Your ref: SSD-23512960
File no: MC-21-00005

SSD-23512960 - Request for advice – Upgrades to Glenwood High School at 85 Forman Avenue, Glenwood

Blacktown Council's submission to SSD-23512960 – Upgrades to Glenwood High School at 85 Forman Avenue, Glenwood

1. Drainage engineering issues

drawing title
SITeworks PLAN

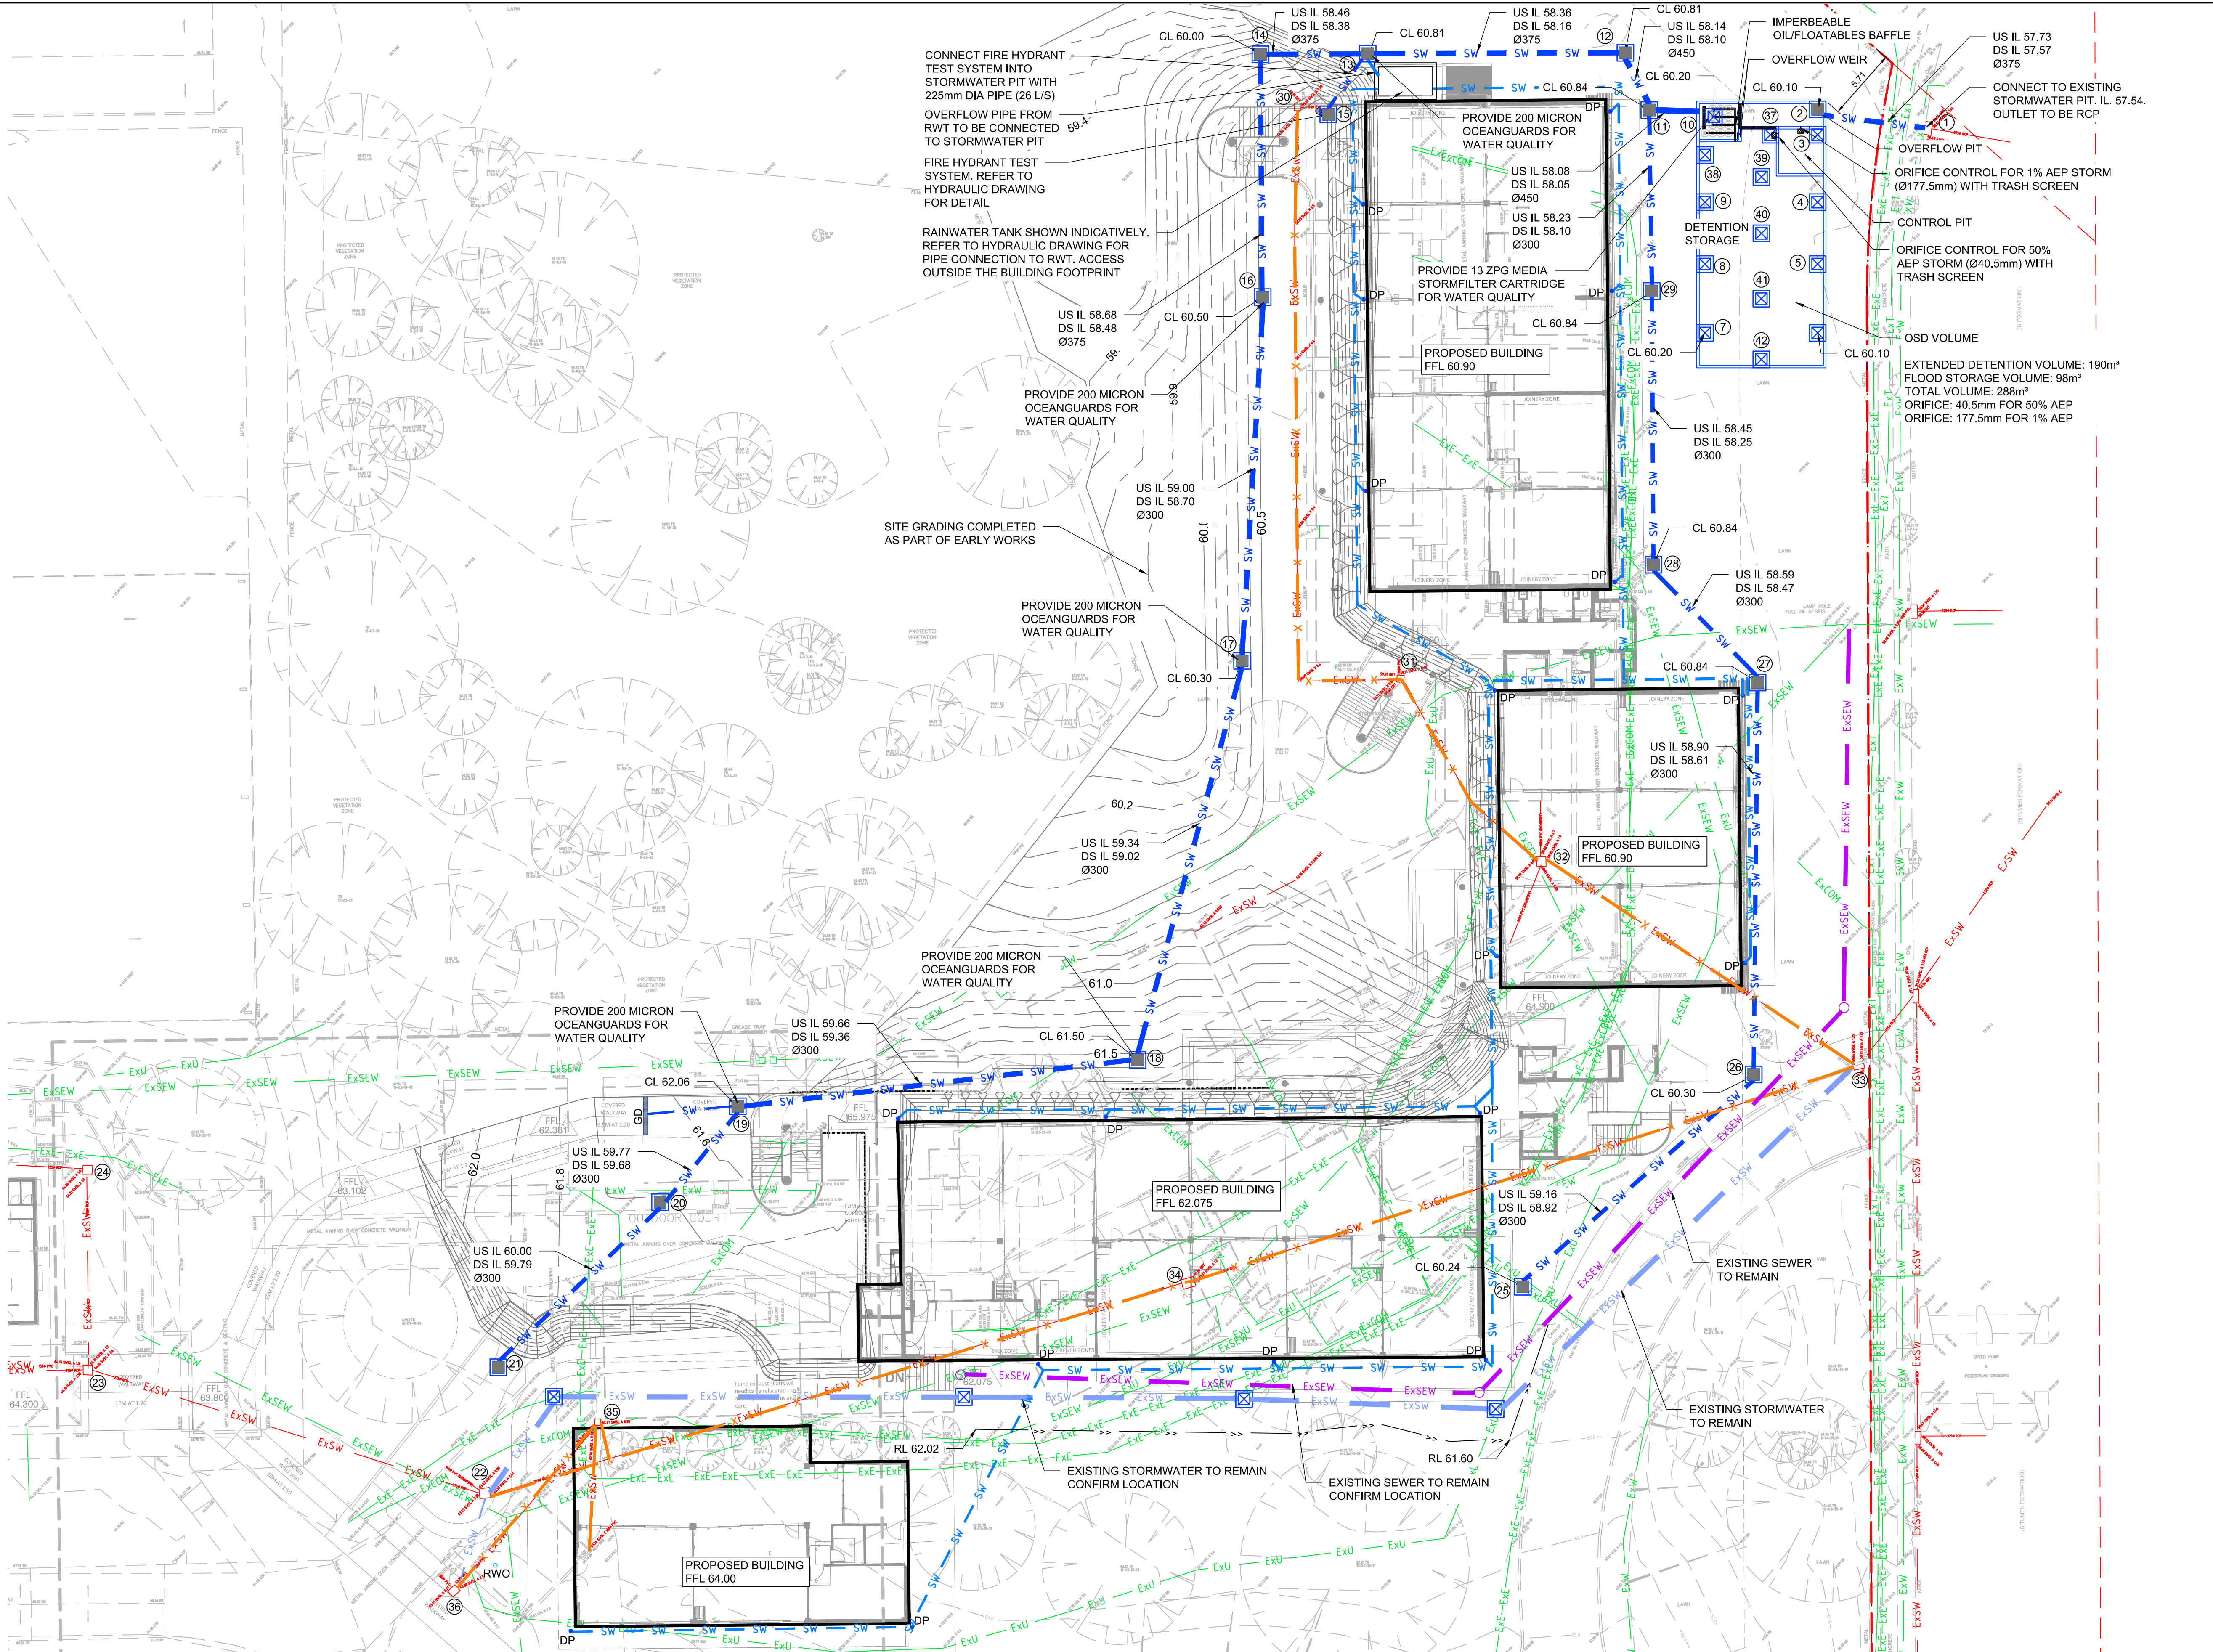
- v. On drawing 0201 (A):
 - a) It seems all the roof water is bypassing the rainwater tank and discharging directly into the stormwater line. Show how the roof water gets to the rainwater tank. Provide a separate system for roof water and surface drainage. Pits between the roof lines (i.e. charged pipes) are to be sealed.

- b) Provide details of the rainwater tank including pre-treatment, volumes, sections, dimensions etc.
 - c) The 375 mm diameter outlet to the existing stormwater Pit 1 is to be RCP.

- d) Provide levels of the existing street Pit 1 and confirm the connection level to this pit.
 - e) Clearly show details of all pits including surface levels and invert levels.

- f) It is unclear whether Pits 18 and 27 are treating surface flows and all or only part of the upstream pipe flows as well. Provide detail for Pit 18 and 27 showing all invert levels for all pipes.

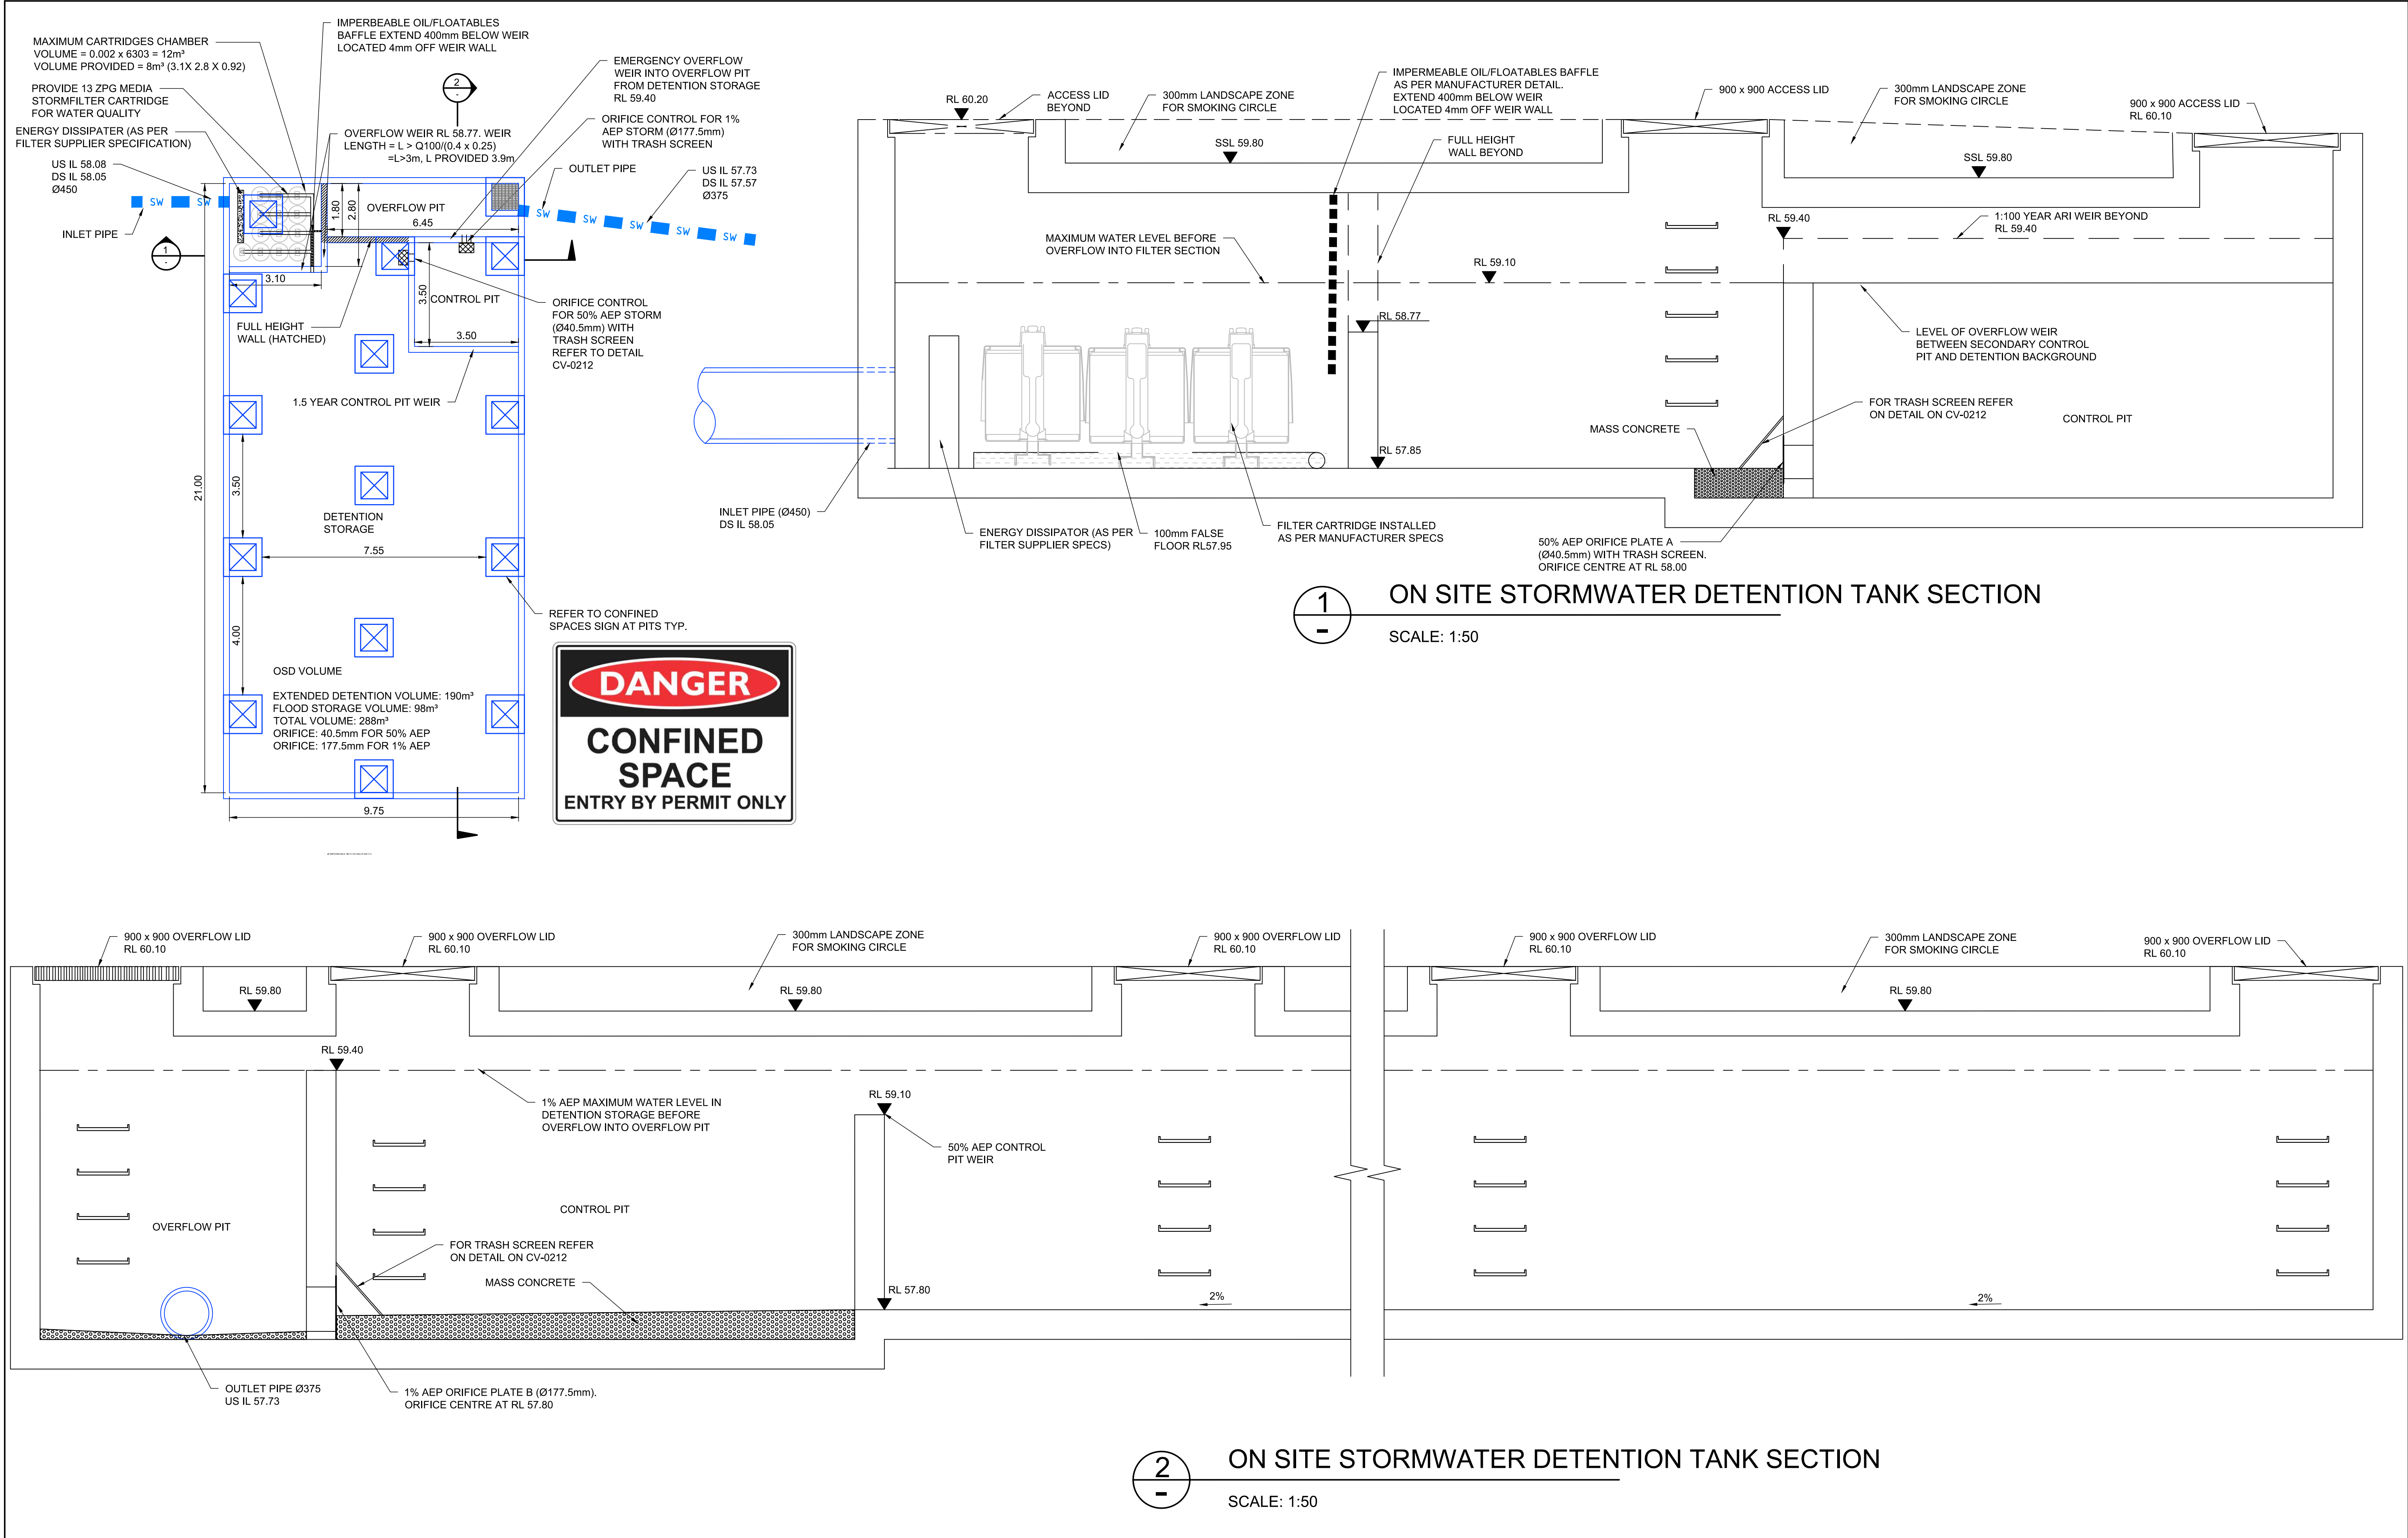
- g) OceanGuards should treat a maximum of 1000 m² of non-roof areas and 1500m² of roof areas. All OceanGuards are to be clearly notated as "200 micron OceanGuards".

- h) OceanGuards treating only surface flows require a minimum clear depth of 500 mm below the grate to any inlet or outlet pipe obvert. OceanGuards treating surface flows and upstream pipe flows require a minimum clear depth of 500 mm from the invert of the upstream pipes to be treated, to the obvert of the outlet pipe. Where these pits are treating upstream pipe flows the inverts of all pipes in and out of the pit are to be shown.

- i) Where OceanGuards (Enviropods) are designed to treat upstream pipe flows, the invert levels on all pipes discharging to and from the pit are to be clearly shown. Provide a minimum clear depth of 500 mm from the invert of the upstream pipes to be treated to the outlet pipe obvert.

- j) Provide a pit detail with an Oceanguard fitted.
- vi. On drawing 0213 (A):
 - a) The 450 mm diameter inlet pipe into the Stormfilter chamber is smaller than the 375 mm diameter outlet pipe from the OSD tank
